**KIRKLEES METROPOLITAN COUNCIL
INVESTMENT & REGENERATION SERVICE**

DELEGATED DECISION TO DETERMINE PLANNING APPLICATIONS

Reference No:	2024/62/92250/W
Site Address:	9, Carr Mount, Kirkheaton, Huddersfield, HD5 0PD
Description:	Erection of extensions to dwelling and detached garage/store
Recommending Officer:	Joanna Rednall

DECISION - REFUSED

Drawing Title
 PROPOSED ELEVATIONS

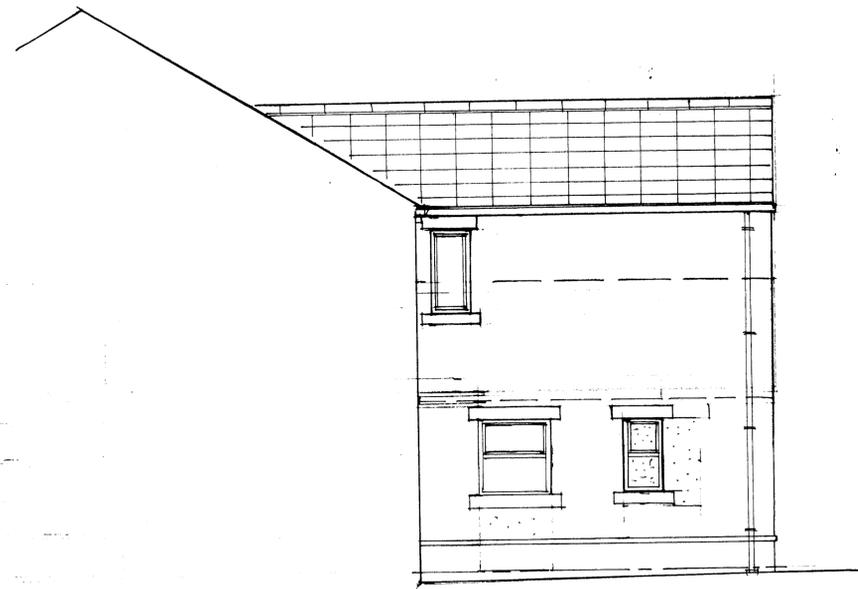
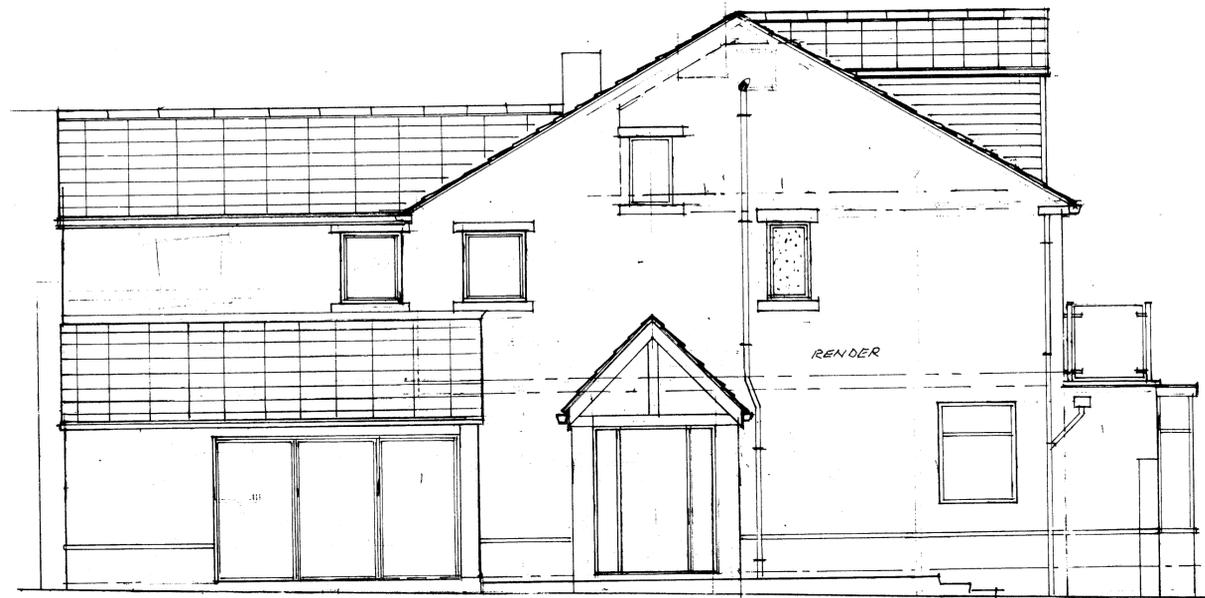
It is proposed that the side extension would be set well back from the original building line and would not exceed 4m in height or extend more than two thirds of the width of the original house. The proposed materials are in keeping with the host property, and the lean-to roof design is considered acceptable for the scale of extension proposed. The fenestration details would be UPVC to match the host property and would face towards the main amenity space of the application dwelling and neighbouring fields to the side. The proposed porch is modest in scale with materials and roof design to match the host. Although it is noted that the proposed side extensions comply with the SPD criteria above, the significant cumulative scale of the proposals fails to remain subservient to the original dwelling. The proposed side extension would therefore have an unacceptable visual impact to the host property and local character, including the Green Belt setting.

The first-floor extension is located to the rear of the property and would be constructed above the existing single storey rear projection. The extension would follow the outrigger of the first floor, increasing the total eave height to 5m and total ridge height to 6.7m. The first-floor extension would appear visually smaller in relation to the original house. This is because the ridge of the extension is appropriately set down from the ridge of the host property with its matching eaves to the host's own. The gable front feature appears subservient to the host and would reflect the design of the proposed roof. The materials and fenestration details would be in keeping with the host property, and the extension retains a gap of at least 1 metre to the boundaries of the site. Whilst this individual extension is of a scale and design relative to its site, this does not overcome the fundamental objections to the principle of development on this site. It is therefore considered that the cumulative impact of the first-floor extension would create a visually unacceptable impact, contrary to Policy LP24 and LP57 of the Kirklees Local Plan.

A balcony is proposed above the front extension and a clear balustrade approximately 1.1m in height is proposed around the perimeter. This would be accessed via UPVC French doors inserted to the front elevation and accessed via a bedroom. The proposed balcony is considered to appropriately abide by the parameters as set out in paragraph 5.28 of the Council's adopted SPD. This addition would not detrimentally overlook neighbouring homes or gardens and would not detrimentally overlook neighbouring dwellings and would provide views over the rear amenity space of No.9 and the adjacent fields.

Notwithstanding the above, it is considered that the cumulative impact of the proposed first floor and balcony extensions in addition to the side, first floor and porch extensions, would cause detrimental harm to the visual amenity of the host dwelling and character of the Green Belt setting. The proposed extensions would not leave the original dwelling the dominant feature and would appear visually disproportionate over and above the size of the original property. a

The dormer in this case is of a significant size and height that would dominate the front roof plane of the host property. The dormer is not set below the ridgeline of the existing property with only a small area of roof retained to the sides and below. The roof of the existing property would be increased in volume to form a gable design. This would unbalance the appearance of the semi-detached property and would create a cluttered and asymmetrical appearance with the addition of the front dormer. There are no existing dormer windows on neighbouring properties, and the windows on the dormer are not aligned with existing openings on the front elevation of the application property. It is therefore considered that the cumulative impact of the front dormer, hip to gable roof, front balcony, and additional extensions above would cause significant harm to the visual amenity of the original property and would form disproportionate additions and would be detrimental to the character of the Green Belt setting.

Drawing Title
**REPLACEMENT
 DETACHED GARAGE
 & STORE**

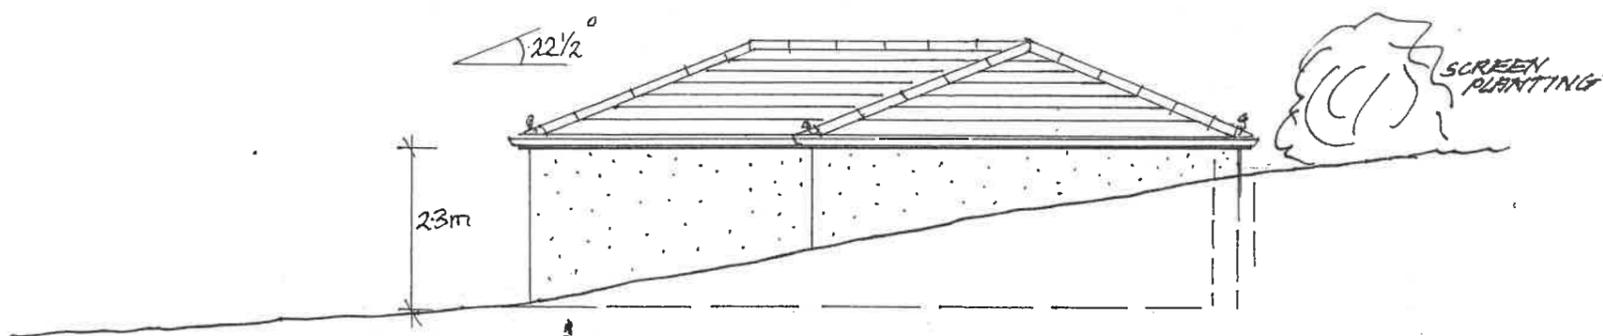
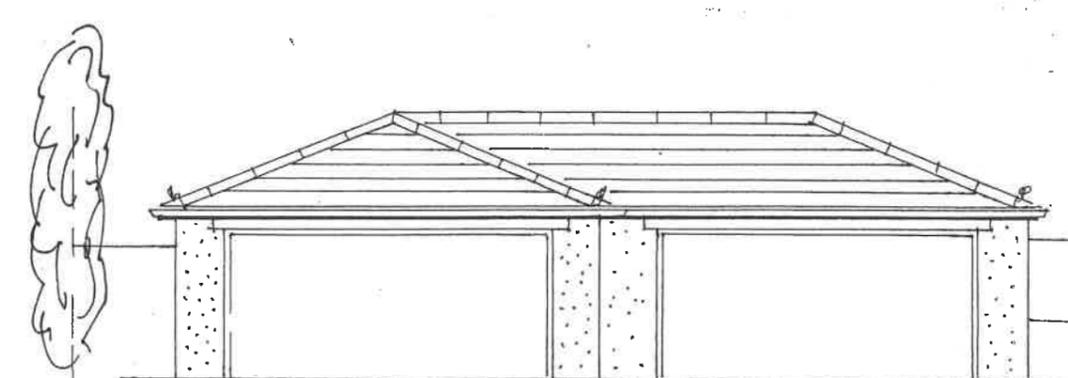
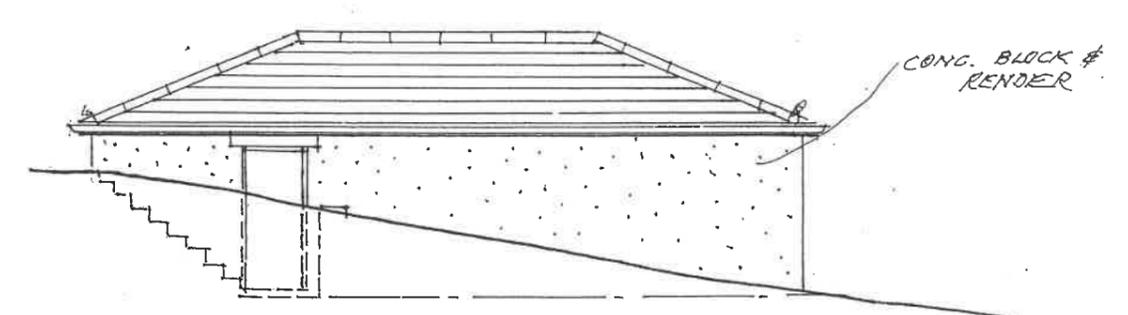
The detached garage would be located in the front amenity space of the dwelling. It is noted on the proposed block plan that the existing garage, measuring 8m x 4m x 2.5m would be demolished. This garage is present on the historic 1955 OS map and would therefore be considered part of the original dwelling. The proposed garage is 'L' shaped, measuring a maximum width of 12m and depth of 10m and a total height of 3.8m. The structure would be separated at a distance of 13m to the front of the property.

The proposed garage would add a significant mass and bulking to the application site. This element of the proposal would result in a footprint larger than that of the original property in a prominent position to the front of the dwelling close to the PROW (KIR/169/10). The garage would therefore not be subservient in footprint to the original building and it is not set behind the building line of 9, Carr Mount. Although the hipped roofing style would mitigate some degree of mass and obtrusiveness of the development and the proposed plans indicate screen planting to the east of the development, this is

not considered to overcome the detrimental harm the outbuilding would cause to the original property and the Green Belt setting. This is because the garage would be significantly larger than the existing outbuilding, with an additional bulk and massing that would over dominate the host property and local character. It is therefore concluded that the garage would result in significant and incongruous development which would be harmful to the character of the host property and local character.
